# INTER-OFFICE MEMO

RE: Project #2021-005461/SI-2023-00513,  
Site Plan-EPC Major Amendment- Wyoming Mall Coffee Shop- Parcel 5-A

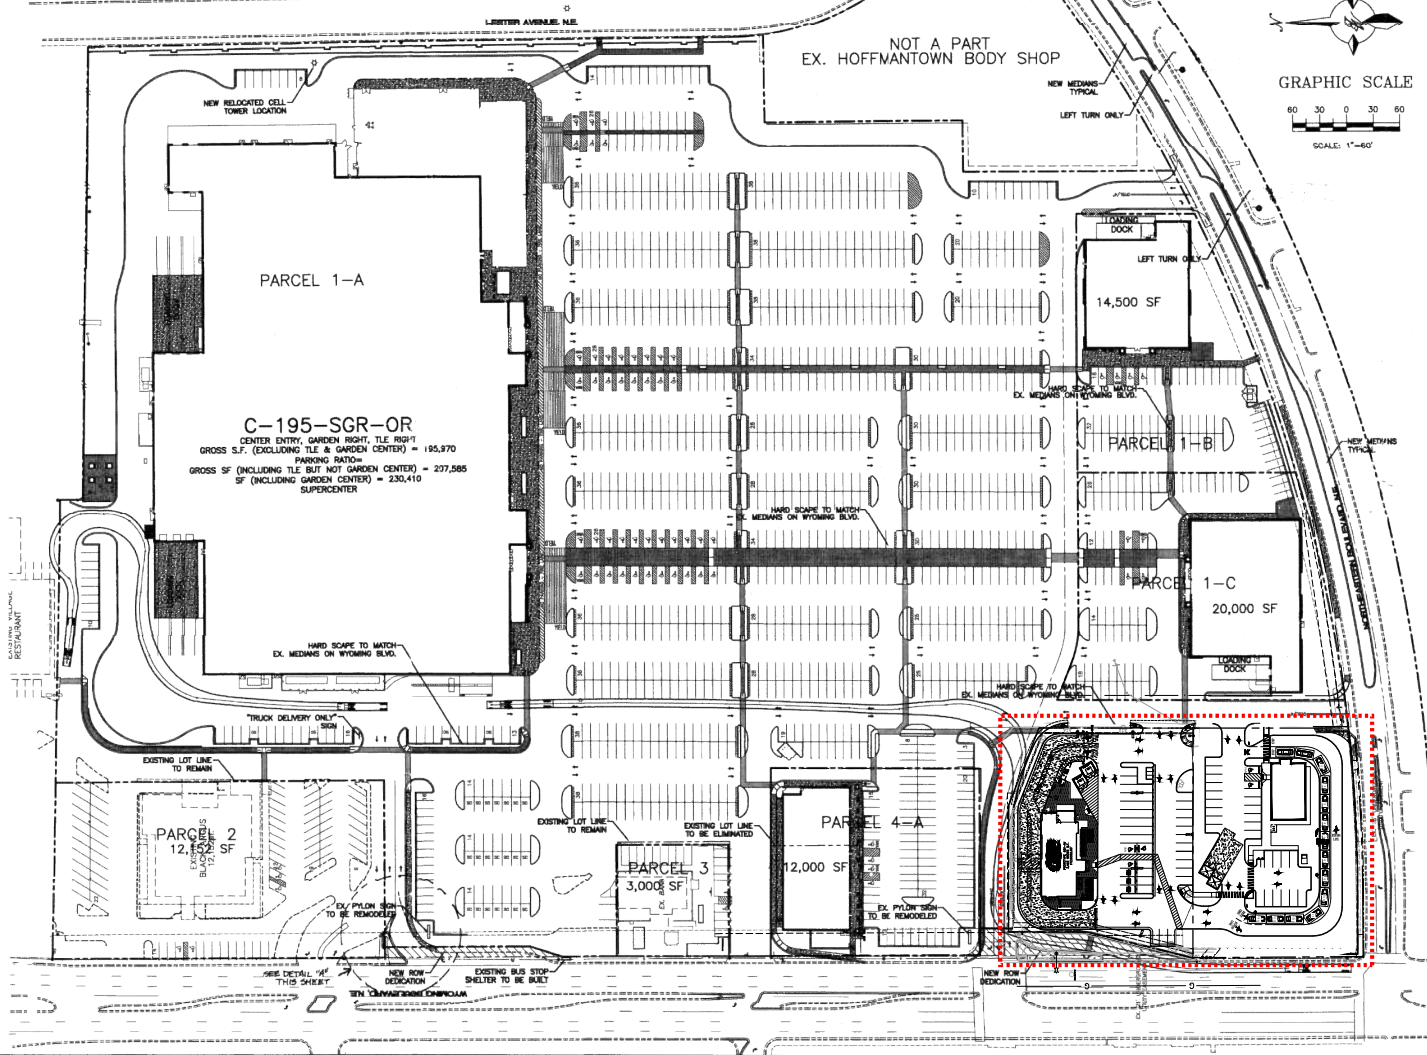
2. The note added to the post-EPC Major Amendment Site Plan is confusing and inaccurate in places.

Staff has revised the note as shown below. Please use the revised, clean version of the note to replace the note on the post-EPC Major Amendment Site Plan. Note: the note should not be in all caps.

The WYOMING MALL DEVELOPMENT WAS ORIGINALLY APPROVED as Project #1003747 (2006). WITH CASE #05DRB-0115. THIS IS THE CONTROLLING SITE Development PLAN FOR THE SUBJECT PROPERTY (Parcel 5-A) OF THIS PROPOSAL, WHICH IS APN 10225901708131301. REVISIONS ARE ONLY PROPOSED ON THE SUBJECT PROPERTY, BUT THE ENTIRE WYHOMING MALL DEVELOPMENT IS SHOWN BECAUSE THIS IS THE CONTROLLING SITE Development PLAN. THE SUBJECT PROPERTY WAS INVOLVED IN ANOTHER EPC APPROVAL, CASE PR#-2021-005461, WHICH PROPOSED a drive-through restaurant THE IMPROVEMENT OF A RAISING CANES ON THE NORTHERN HALF OF THE SUBJECT PROPERTY. THE CURRENT request PROPOSAL, CASE #SI-2023-00513, PROPOSES a drive-through coffee shop IMPROVEMENT OF A STARBUCKS ON THE SOUTHERN HALF OF THE SUBJECT PROPERTY AND is not intended DOES NOT PROPOSED TO IMPACT THE existing drive-through restaurant. PREVIOUSLY APPROVED AND CONSTRUCTED RAISING CANE'S IMPROVEMENTS.

The Wyoming Mall Development was originally approved as Project #1003747 (2006). This is the controlling site Development Plan for the subject property (Parcel 5-A). Revisions are only proposed on the subject property, but the entire Wyoming Mall Development is shown because this is the controlling Site Development Plan. The subject property was involved in another EPC approval, PR#-2021-005461, which proposed a drive-through restaurant on the northern half of the subject property. The current request, Case #SI-2023-00513, proposes a drive-through coffee shop on the southern half of the subject property and is not intended to impact the existing drive-through restaurant.
